Demolition of existing buildings and erection of 2 no. dwellings with associated car ports/parking, alterations to existing access and relocation of staircase to flats -
Amendment to EP/138/17/PL

Land rear of Beechlands Cottages Beechlands Close EAST PRESTON

Thank you for your internet representation made on 21st March 2018 which has been recorded as '**an objection**' with the comments as follows:

I am commenting on this application on behalf of the East Preston and Kingston Preservation Society.

Proposed Plans and Elevations

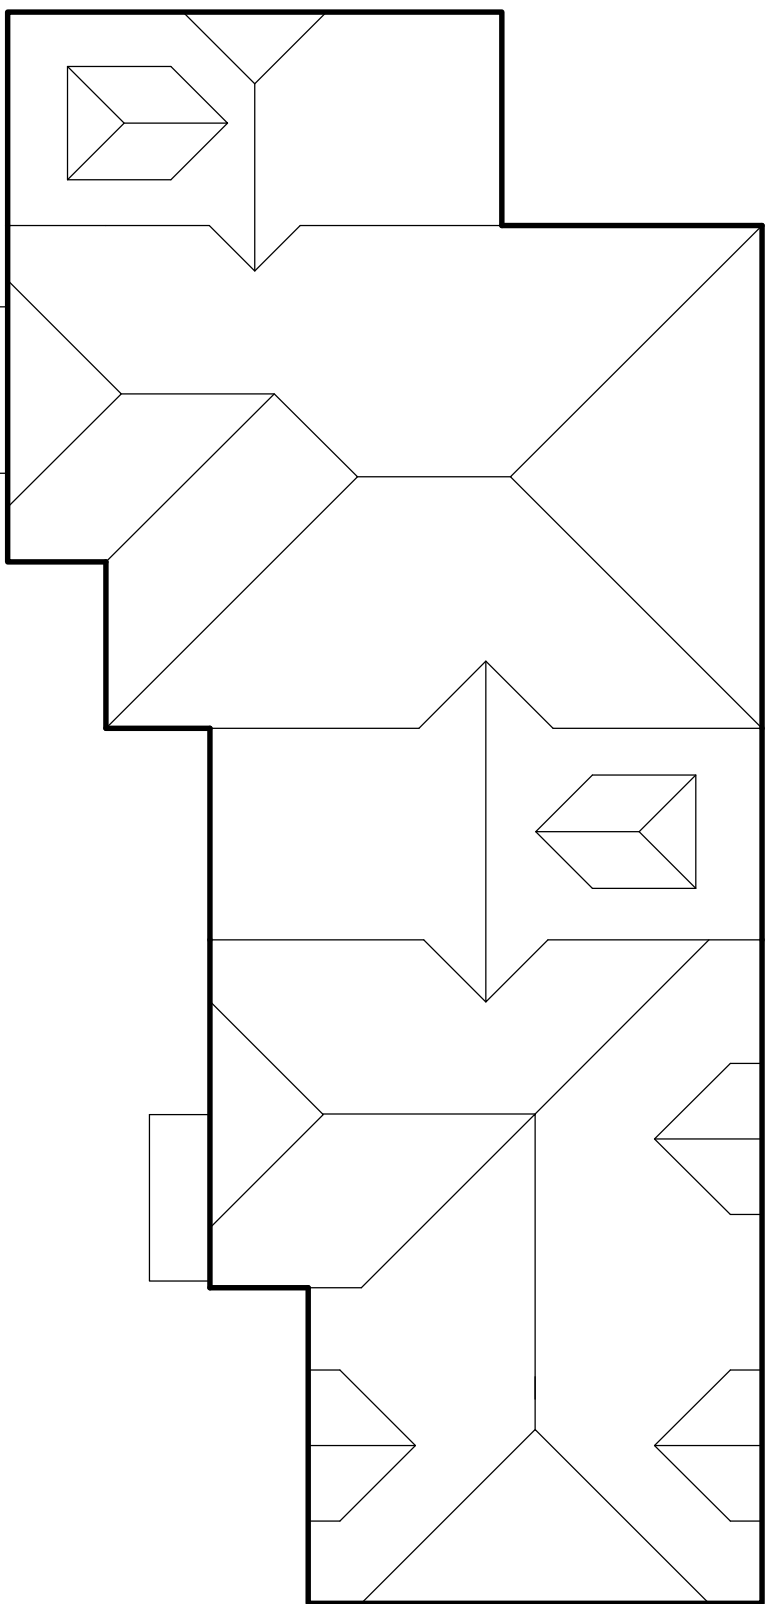
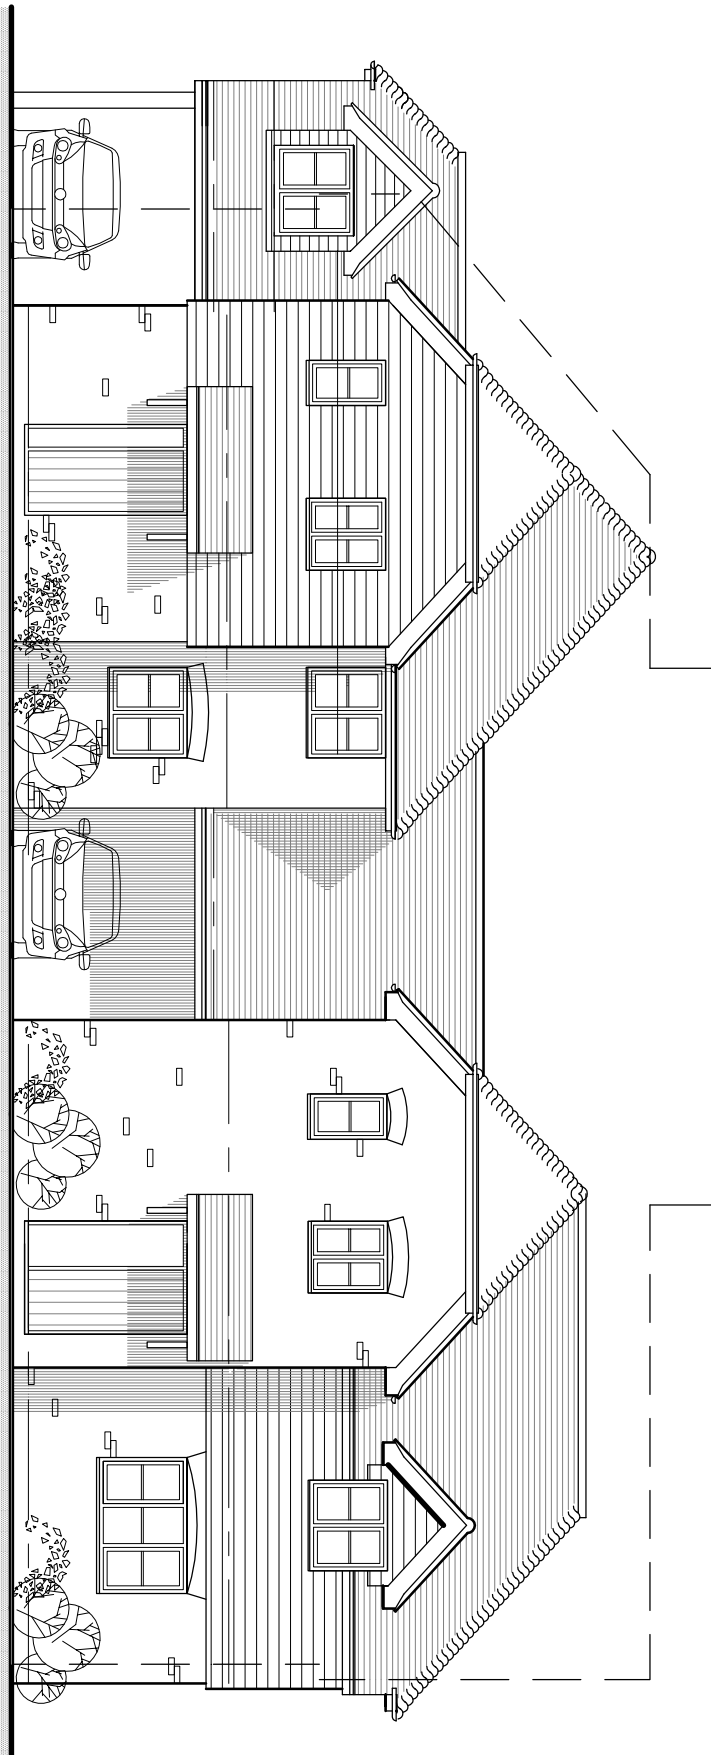
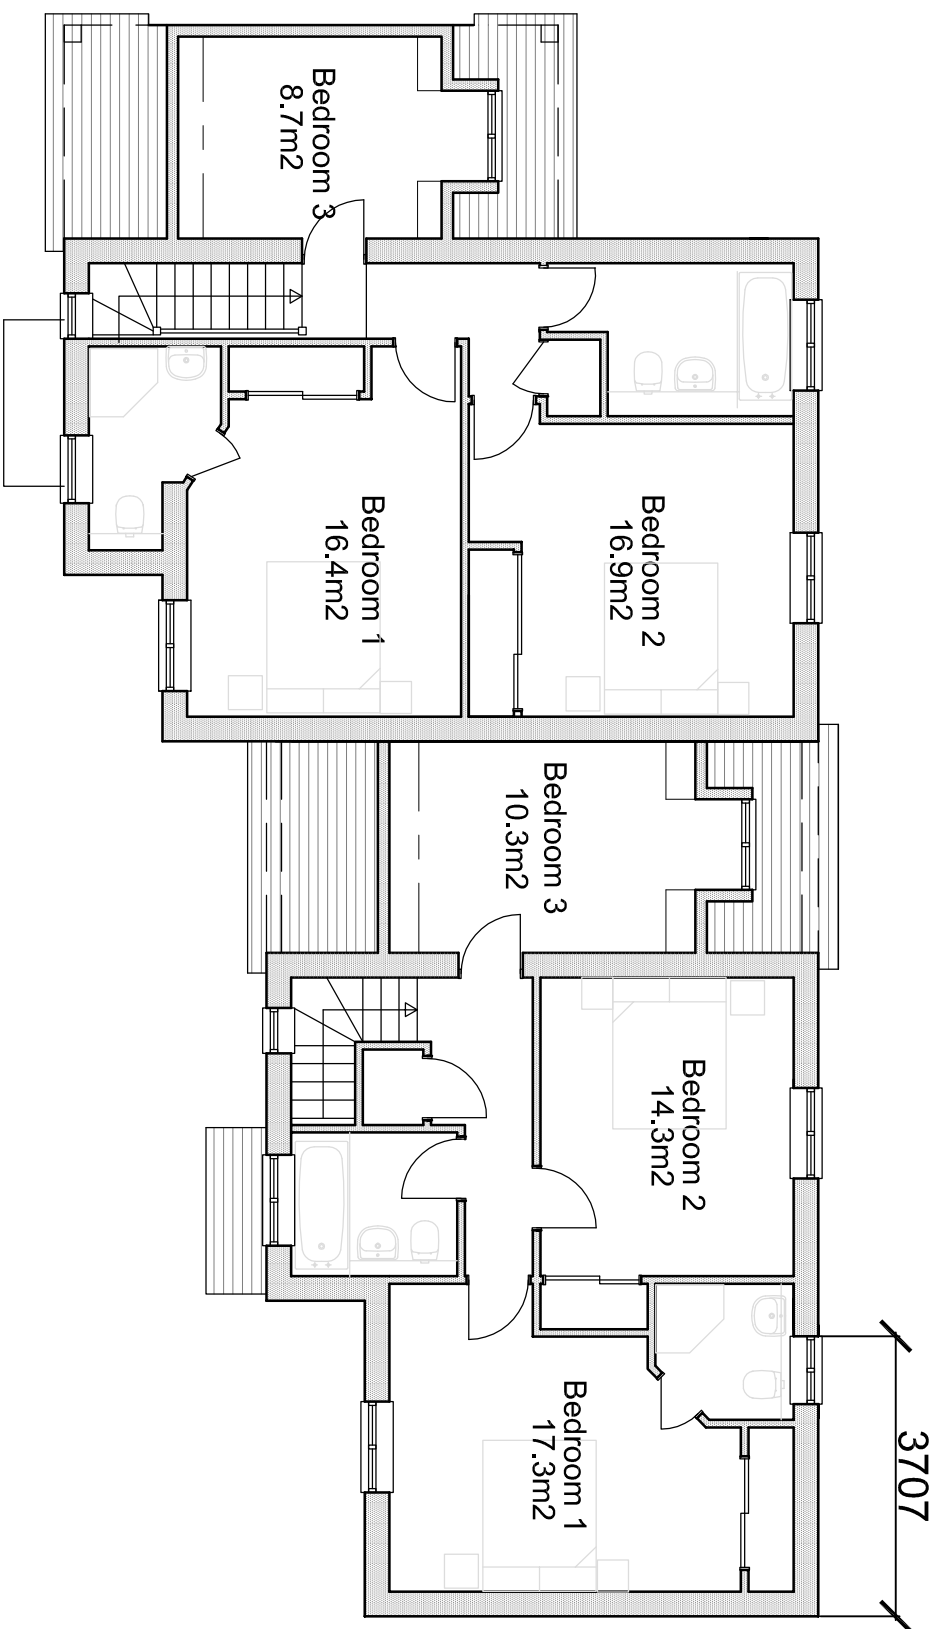
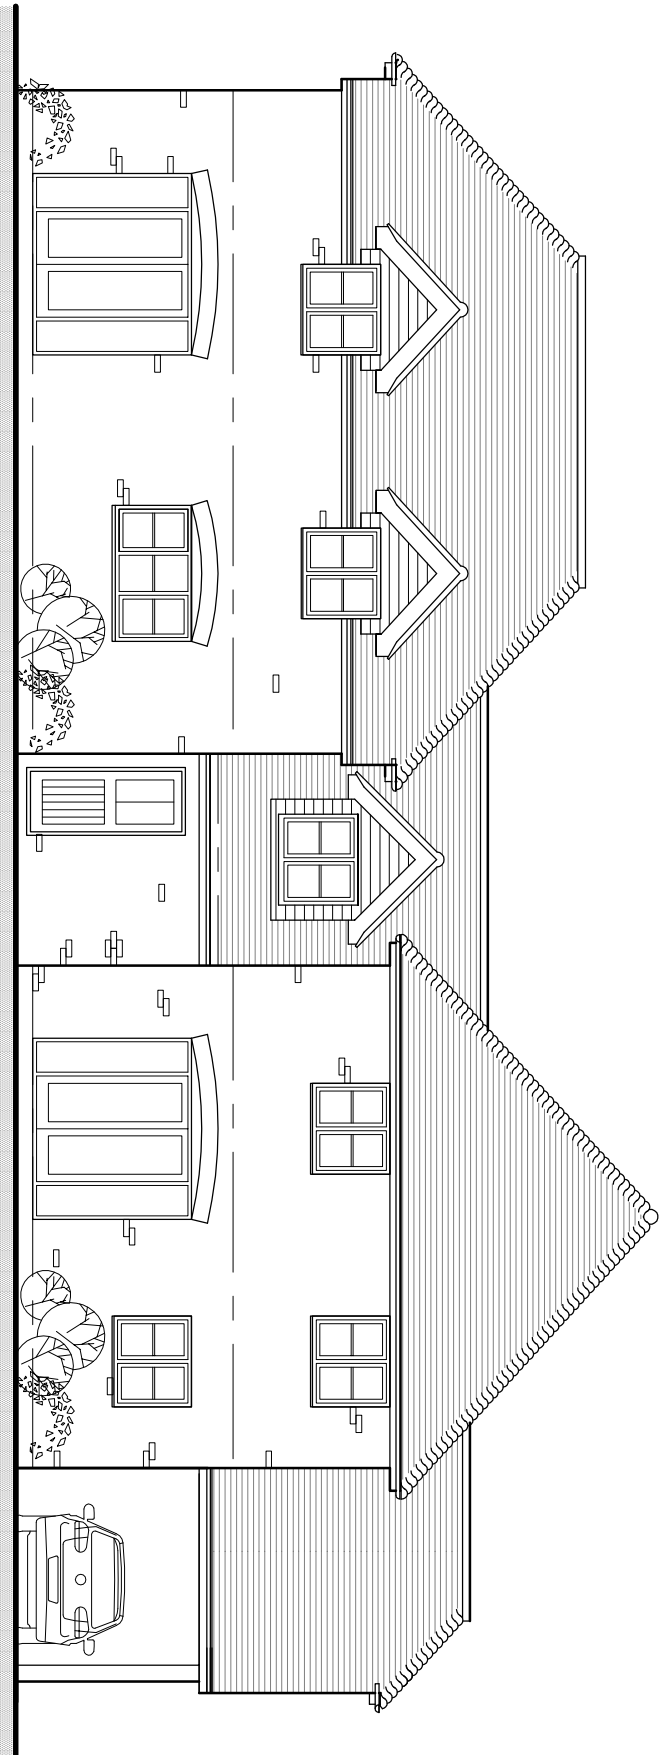
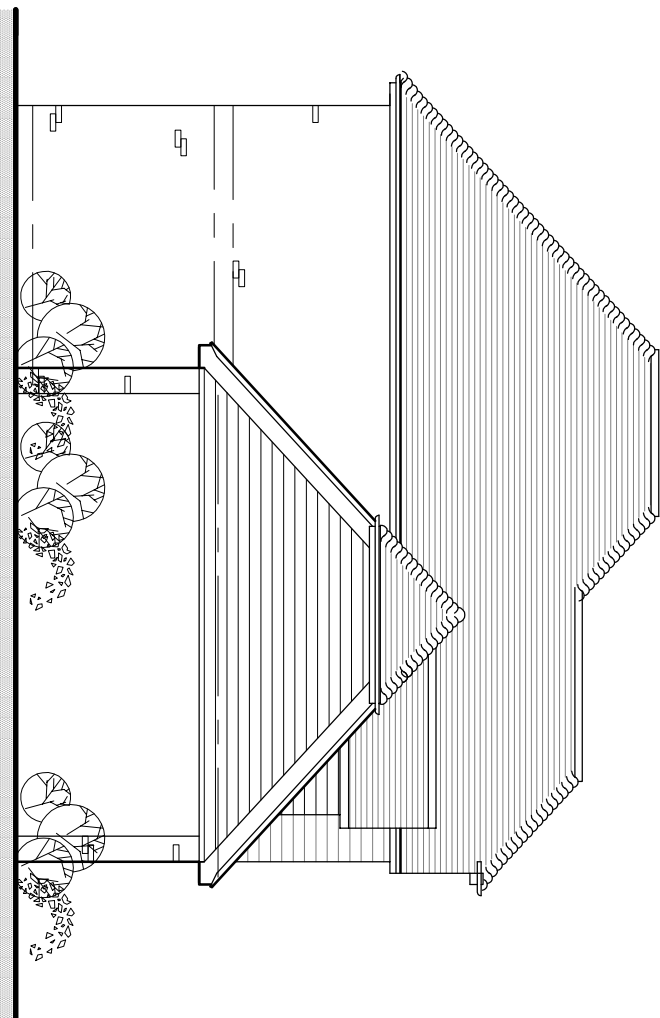
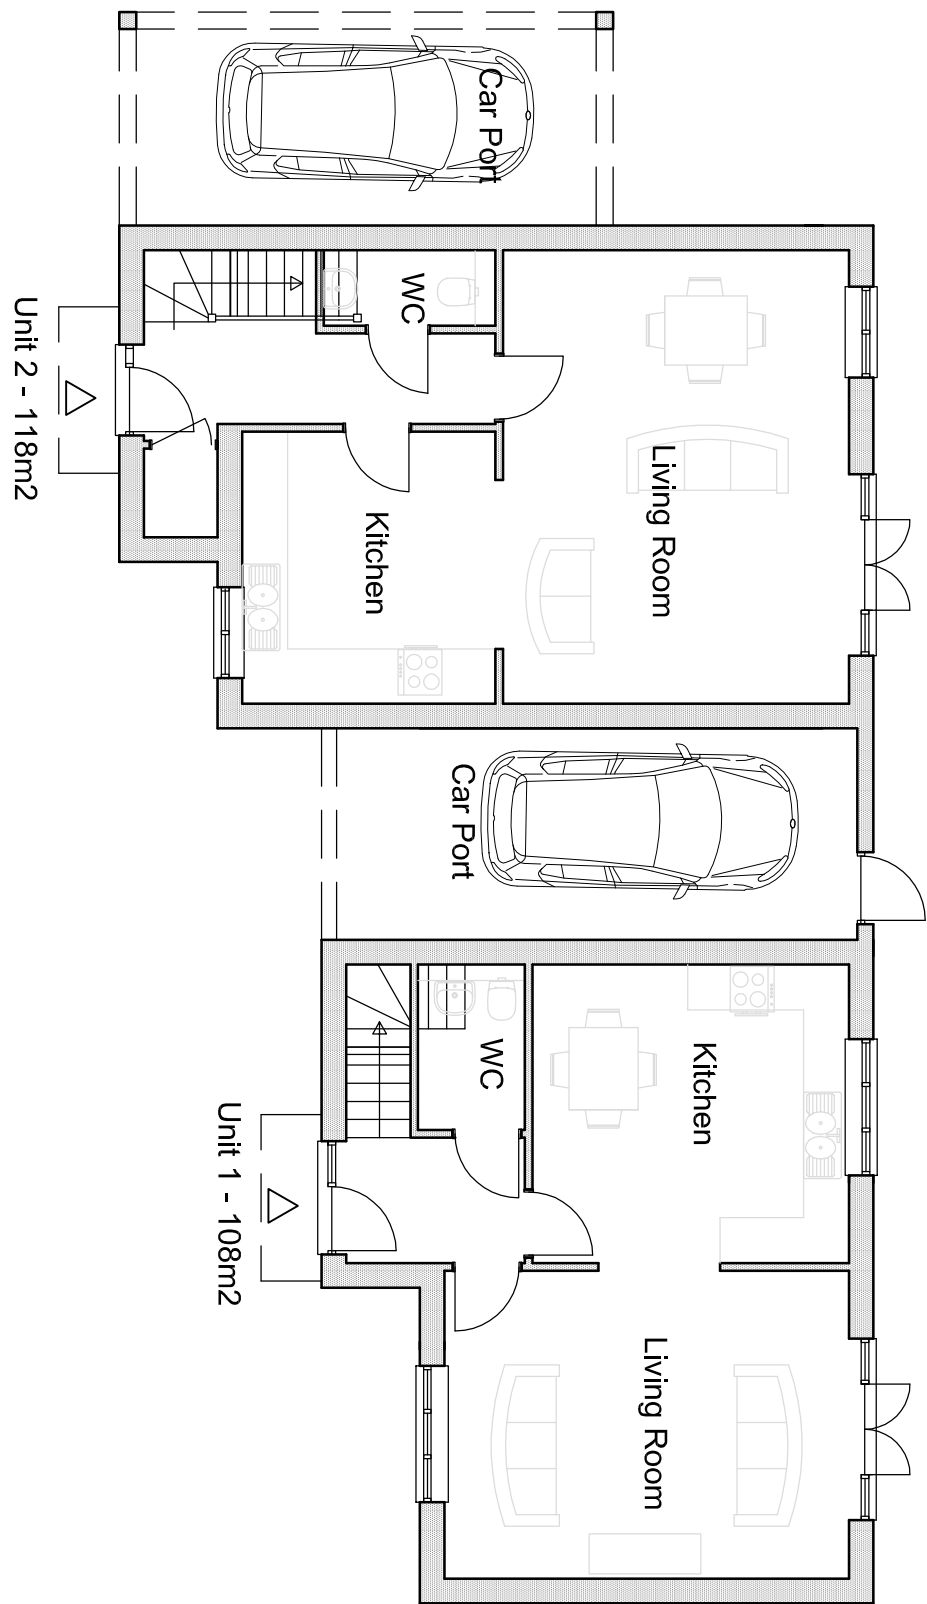
Places the proposed houses too close to the existing and proposed Beechlands Cottages, so that the distance between bedroom windows would be 20-21 metres and overlooking would occur. The proposed houses would have an unacceptably adverse effect on the amenities of these existing or approved houses, which would be contrary to Policy GEN7 (iv) of the Arun Local Plan.

DRAWING TITLE
Proposed Site Plan, Block Plan
and Location Plan

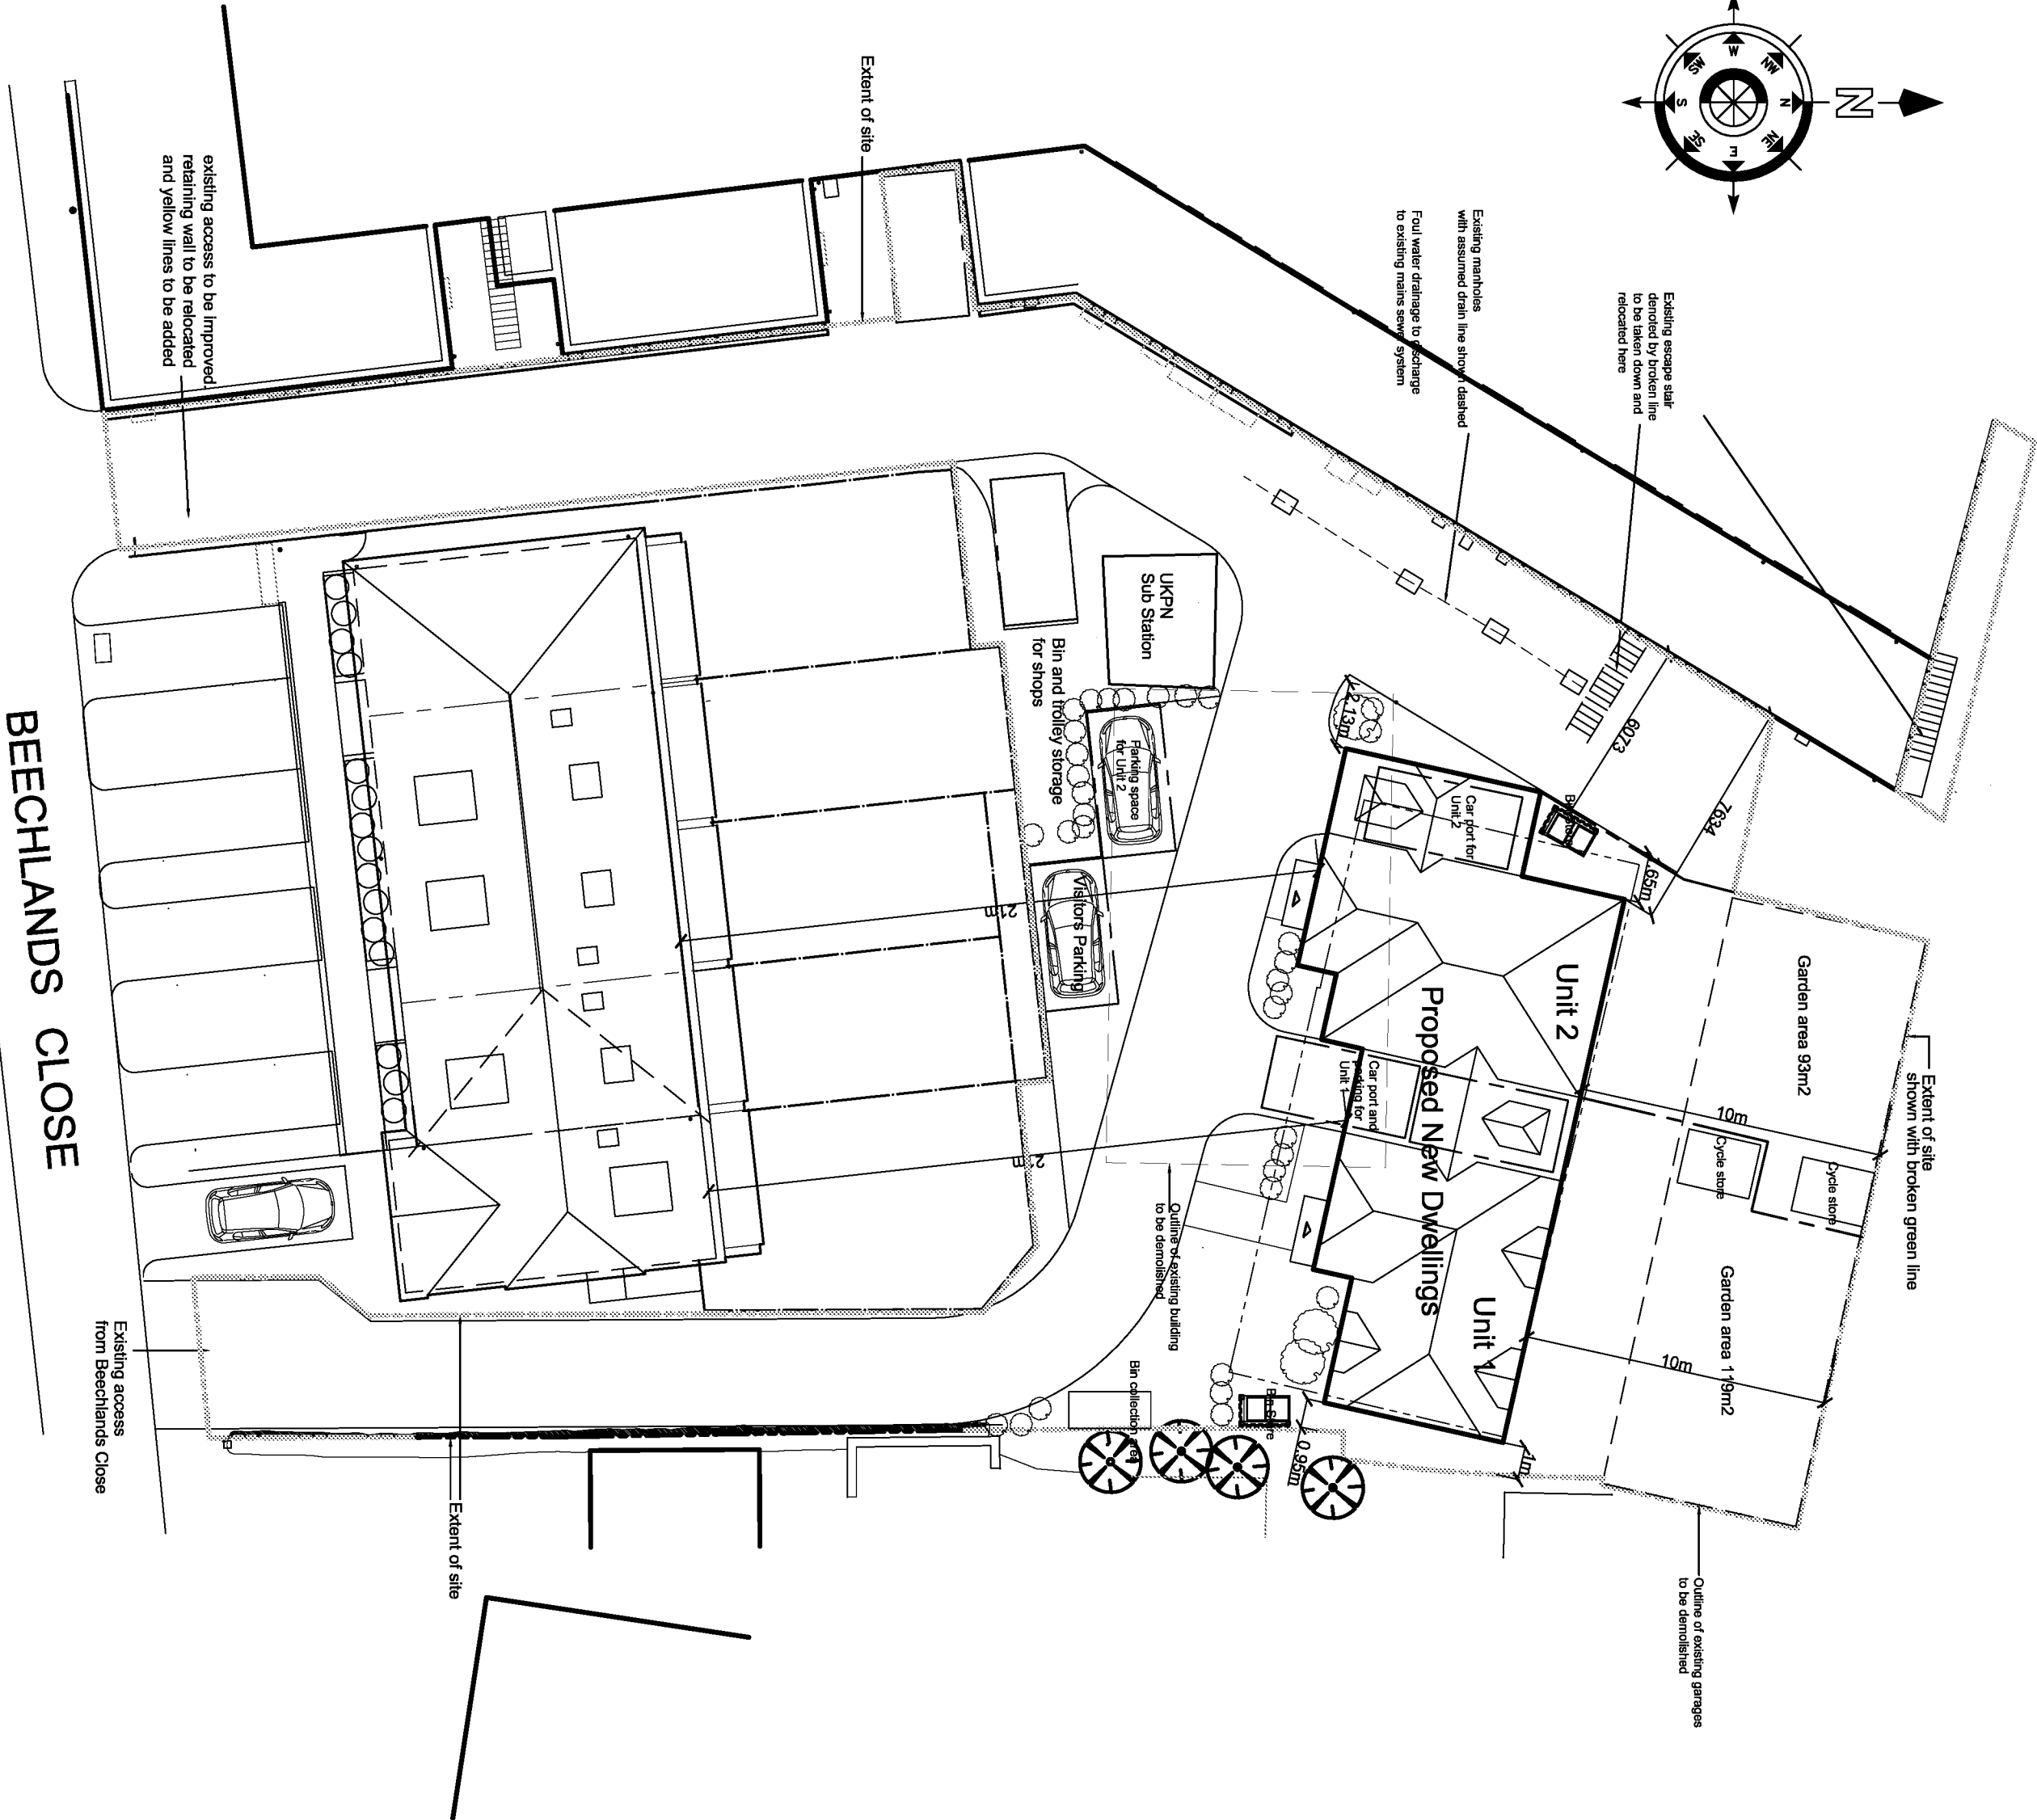
Despite the comments from WSCC, we consider that the development would hamper access to the vehicle entrance to 125 North Lane and would also hamper vehicle access for deliveries to the rear of the shops, at 127-143 North Lane. The development would therefore have an unacceptably adverse effect on the use of these properties, again contrary to Policy GEN7 (iv) of the Arun Local Plan.

The provision of five parking spaces for two houses is now in line with WSCC guidelines, but the development would displace at least 12 vehicles that would presumably end up parking on the already crowded streets. The development would therefore be contrary to the spirit of Policy 1 ii of the East Preston Neighbourhood Plan.
